PLANNING REF: PAA/86/19 – Angels Nursery, Barnham

PRE-APPLICATION RESPONSE - HOUSING STRATEGY AND ENABLING MANAGER ARUN DISTRICT COUNCIL

ANGEL'S NURSERY, BARNHAM - 1 BED APARTMENTS ELEVATIONS AH [BRICK]

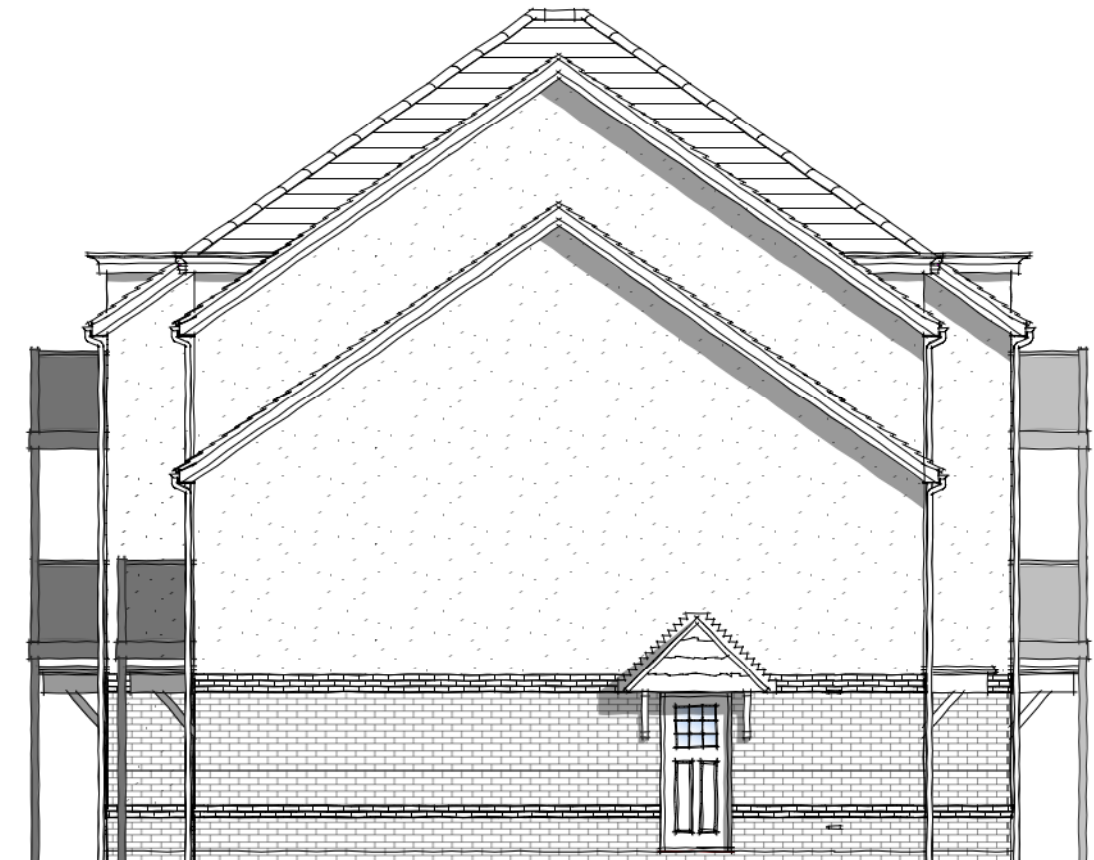
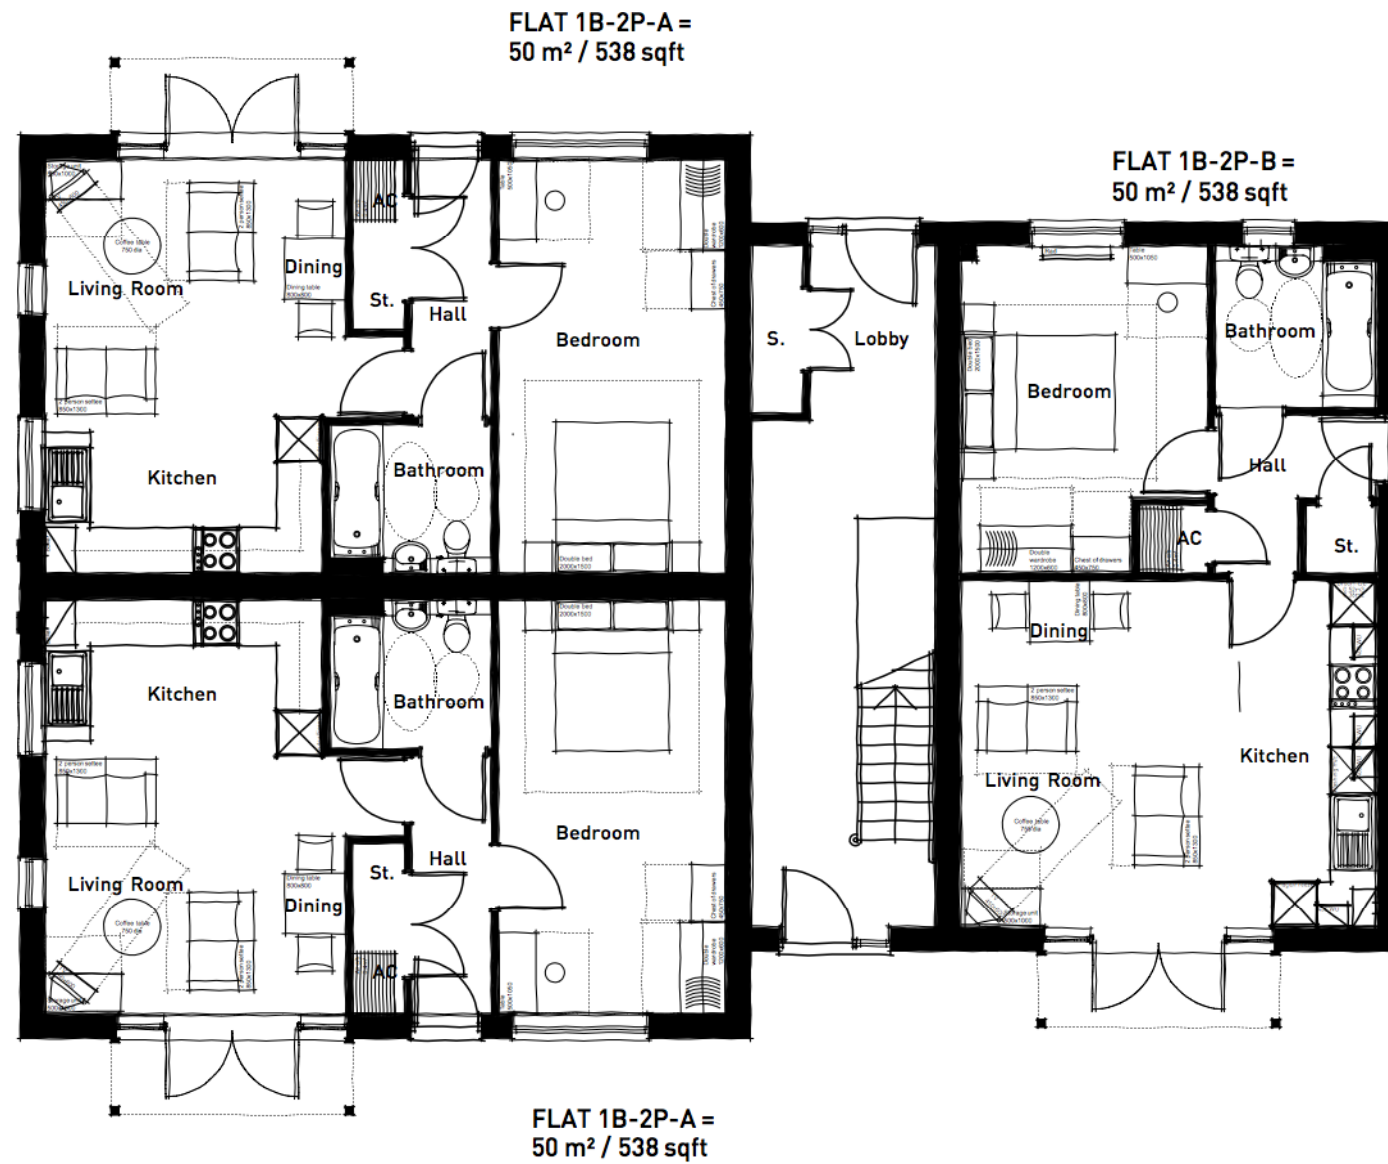
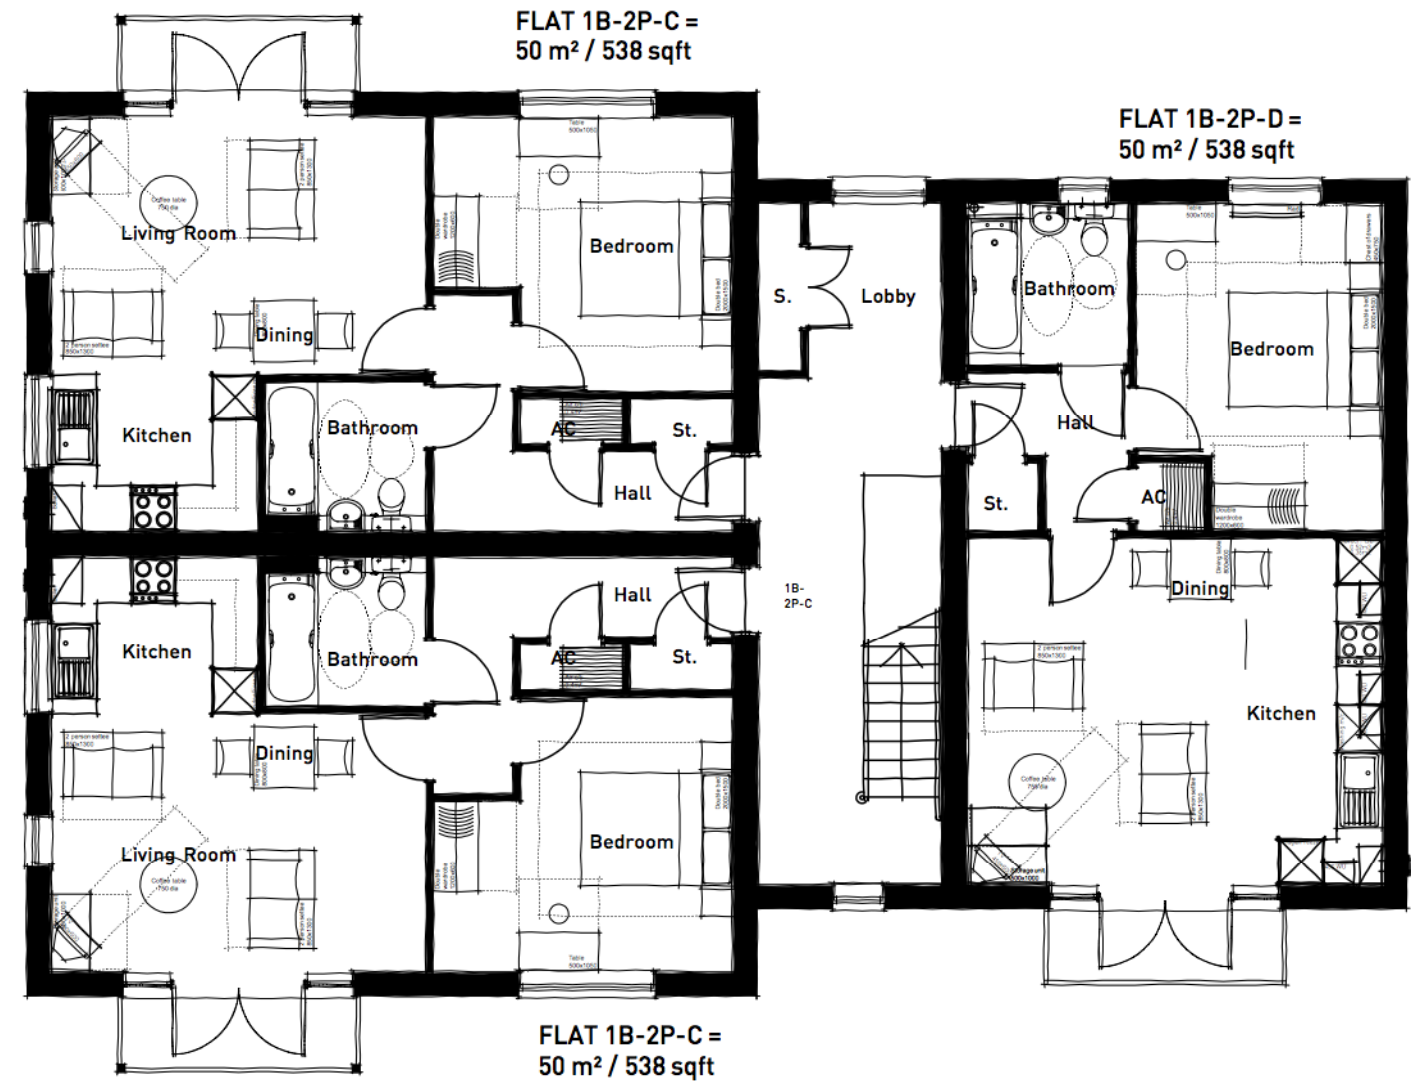
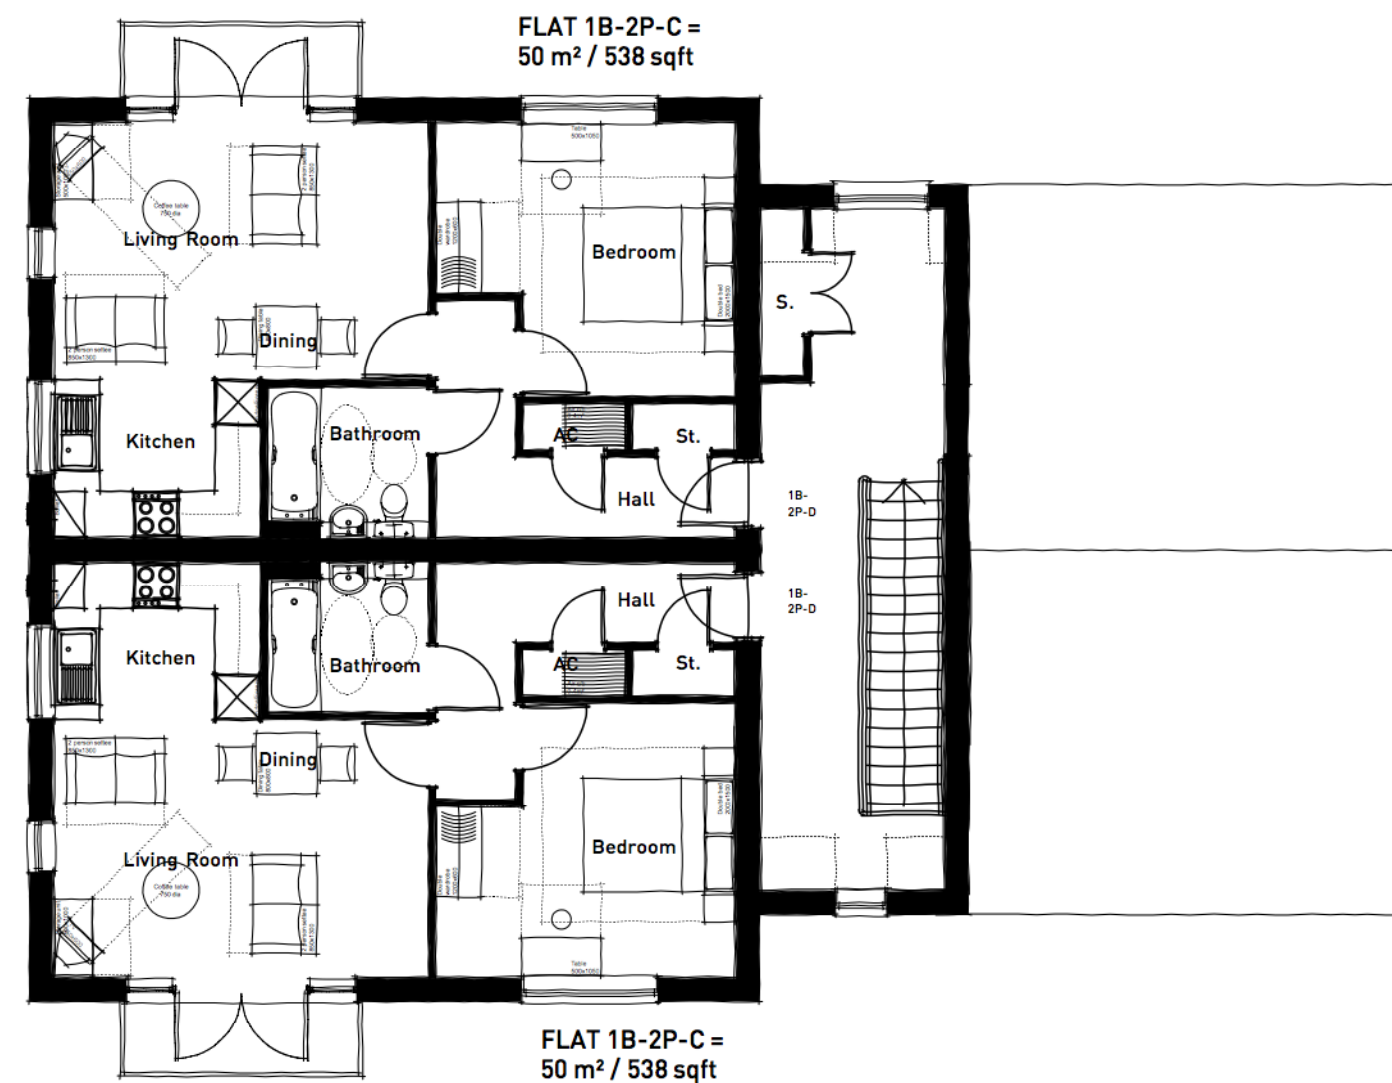
There is concern regarding the location of the 1 bed houses and 2 bed flats, in that it concentrates the majority of the affordable housing into one area. We would like to see consideration given to the relocation of one of these blocks.
